Lead Local Flood Authority
Post Point CHN 215
Hertfordshire County Council
County Hall, Pegs Lane
HERTFORD SG13 8DN

Date 15 April 2021

**RE: Surface Water Advisory Service – Hertfordshire Constabulary HQ,
Stanborough Road, Welwyn Garden City, AL8 6XF**

Catchment 1 - Drains to Outfall A unrestricted
 Catchment 2 - Drains to Outfall B unrestricted
 Catchment 3 - Drains to Outfall B restricted

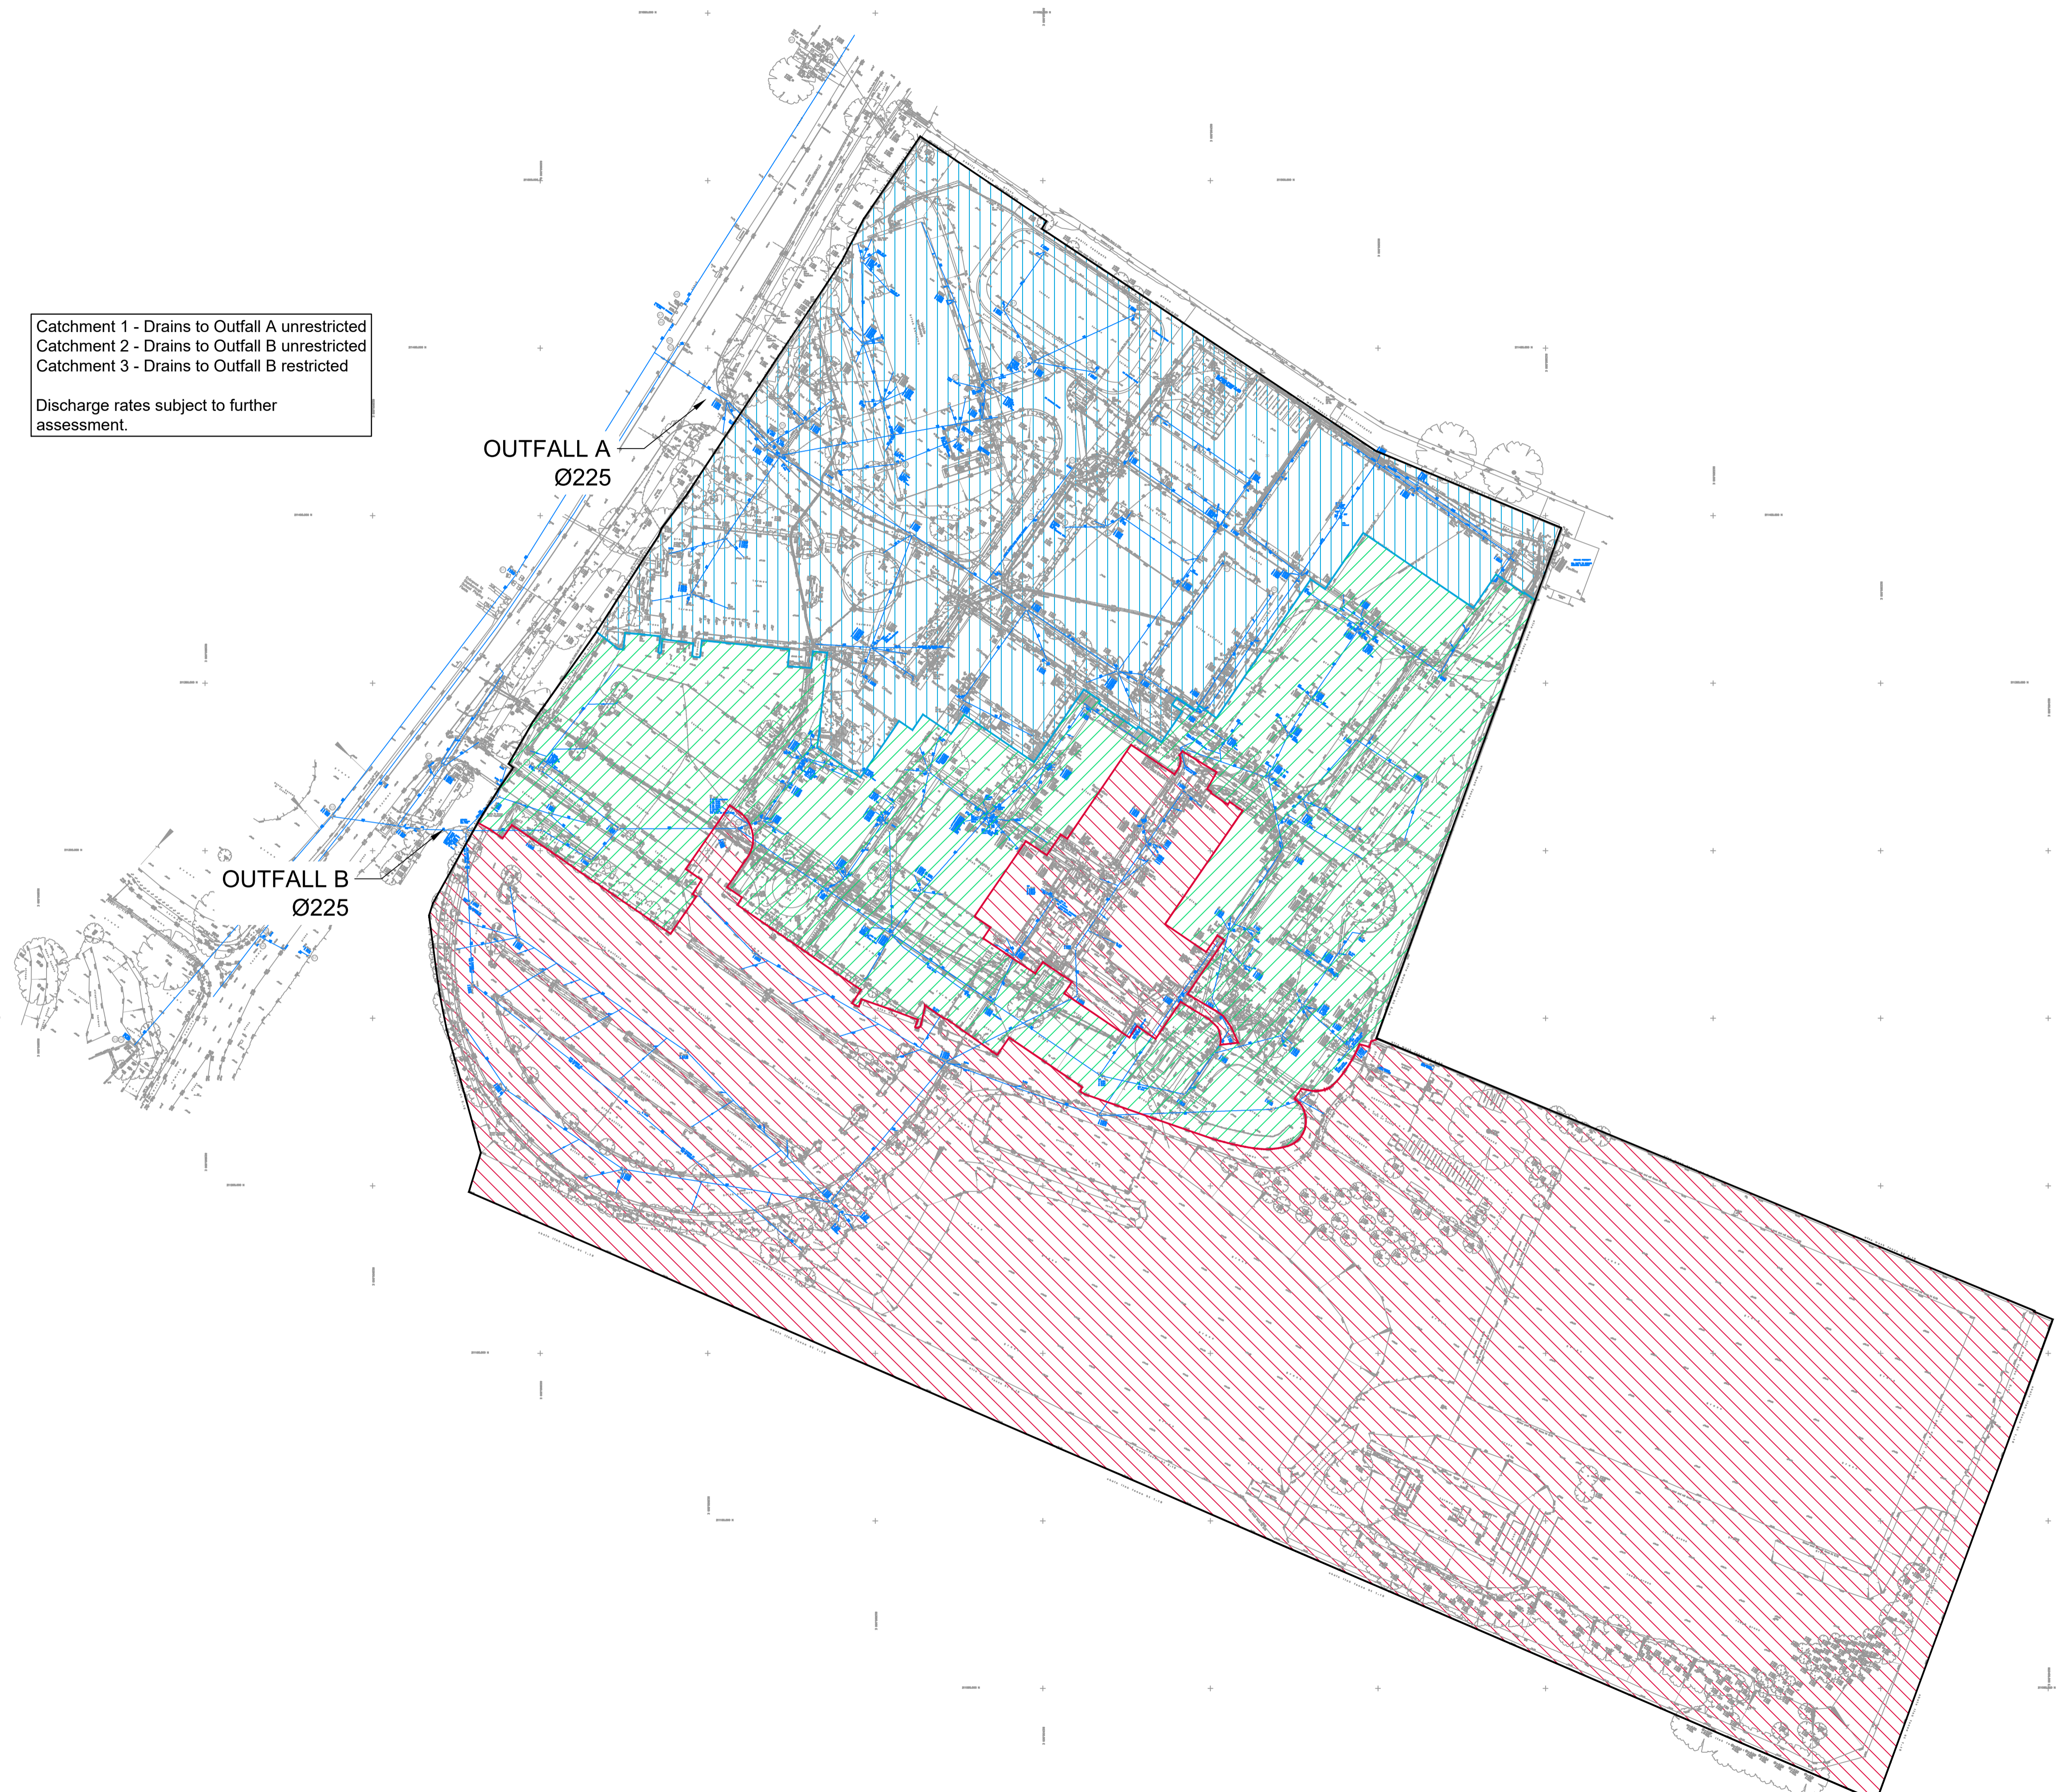
We note the inclusion of tanked storage as a means of providing additional attenuation volumes. Whilst in principle this is acceptable, we would expect to see the applicant provide adequate justification that all other methods of storage have been assessed.

We note that it is proposed to use the existing pond feature, with a proposed extension to accommodate the additional attenuation volume that is required. We note it was discussed in the meeting that a sediment forebay be added to the outfall from the car parking area into the pond feature to provide a treatment stage for the application.

We note that whilst on site we saw no evidence of a restriction device on the outlet pipe located in the existing pond feature. As the applicant intends to use this feature to discharge the surface water run-off for the development, we would expect the overall discharge to be restricted and the location of the restriction device to be highlighted. We would expect the applicant to restrict the discharge rate of the proposed development down to the Qbar for the site.
